# Rezoning Transportation Analysis

Petition Number: 2020-086

General Location Identifier: Tax ID 04708214

Date	Description
07-22-20	First Review
10-26-20	Second Review

OVERALL SITE PLAN

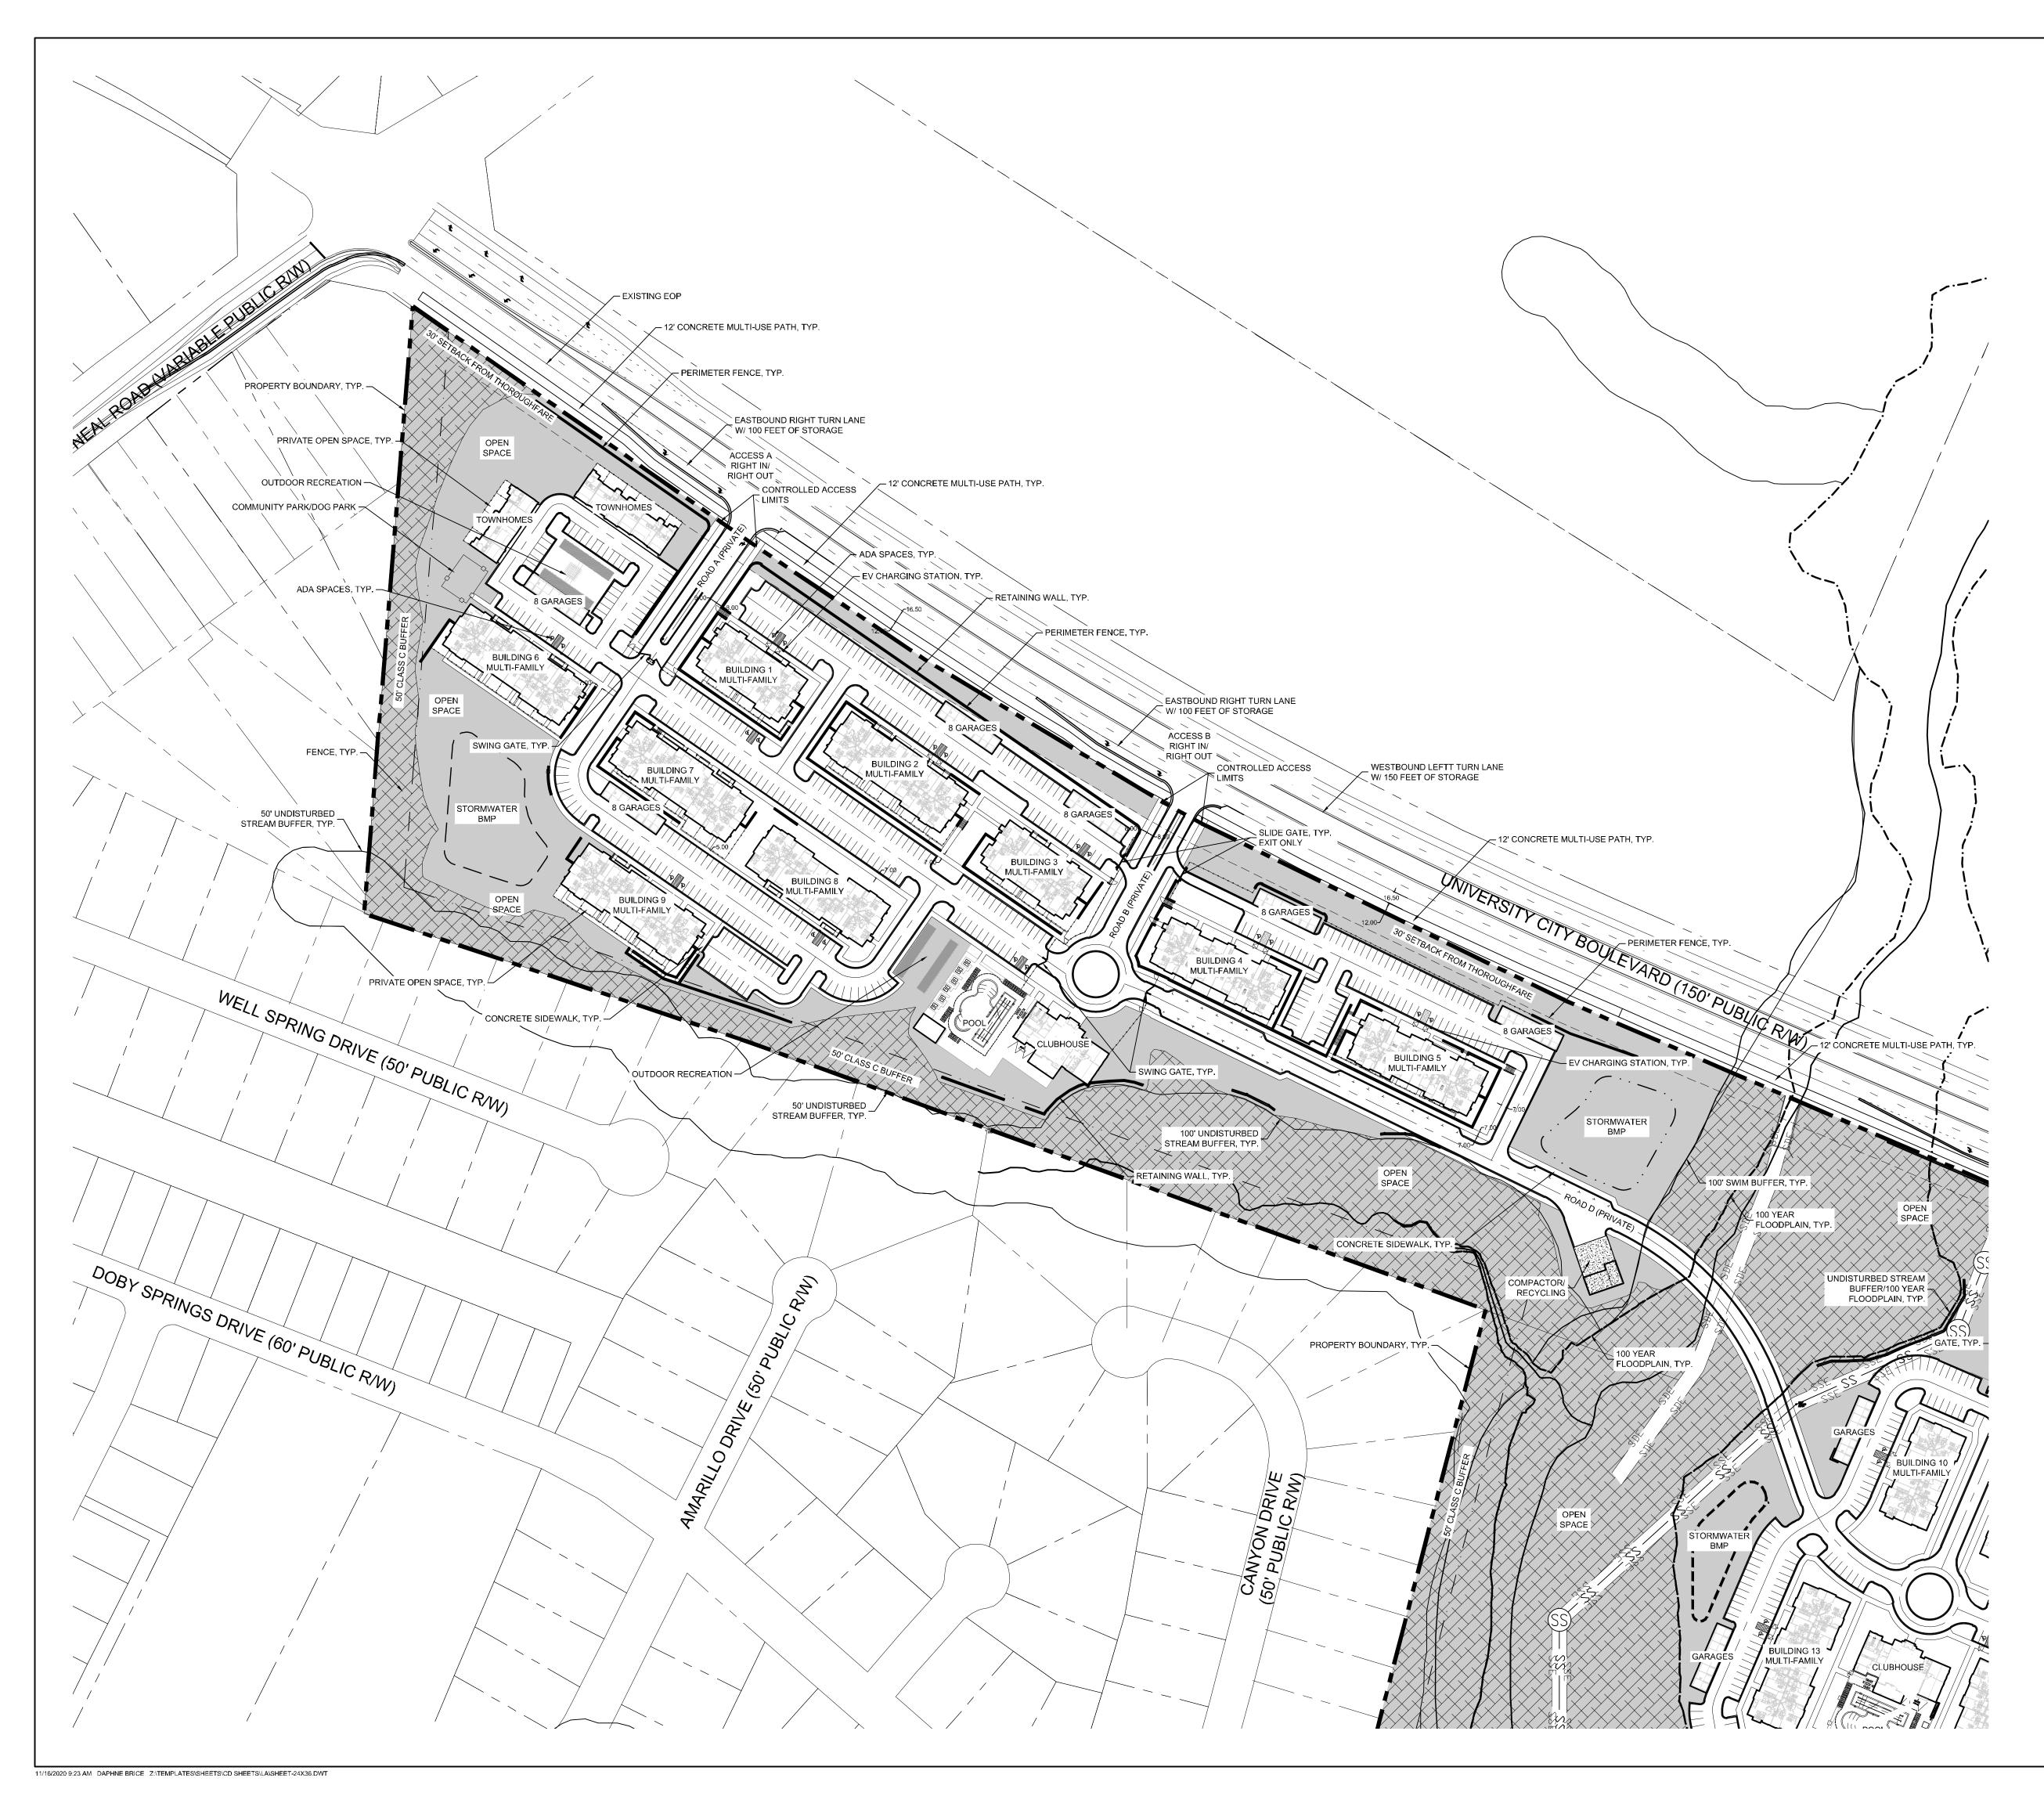
- The petitioner should revise the site plan and conditional note(s) to commit to installing a 12' multi-use path along the site's frontage on University City Blvd to meet the City Charlotte BIKE Policy.

- The petitioner should revise the site plan and conditional note(s) to commit to constructing a shared use path from Doby Springs Drive including a structure over Doby Creek to provide pedestrian and bicycle access to adjacent subdivision in accordance with the Charlotte WALKS Plan and Charlotte BIKES Plan.

- Outstanding (site plan dated 10/12/2020)** The petitioner should revise the site plan and conditional note(s) to commit to constructing a Public street connection to Mineral Springs Road, including a box culvert over Doby Creek. to improve connectivity by providing a north south connection to access University Blvd.

- The petitioner should revise the site plan to add a note specifying dedication and fee simple conveyance of all rights of way to the City before the site's first building certificate of occupancy is issued. CDOT requests right of way set at 2' behind back of sidewalk where feasible.
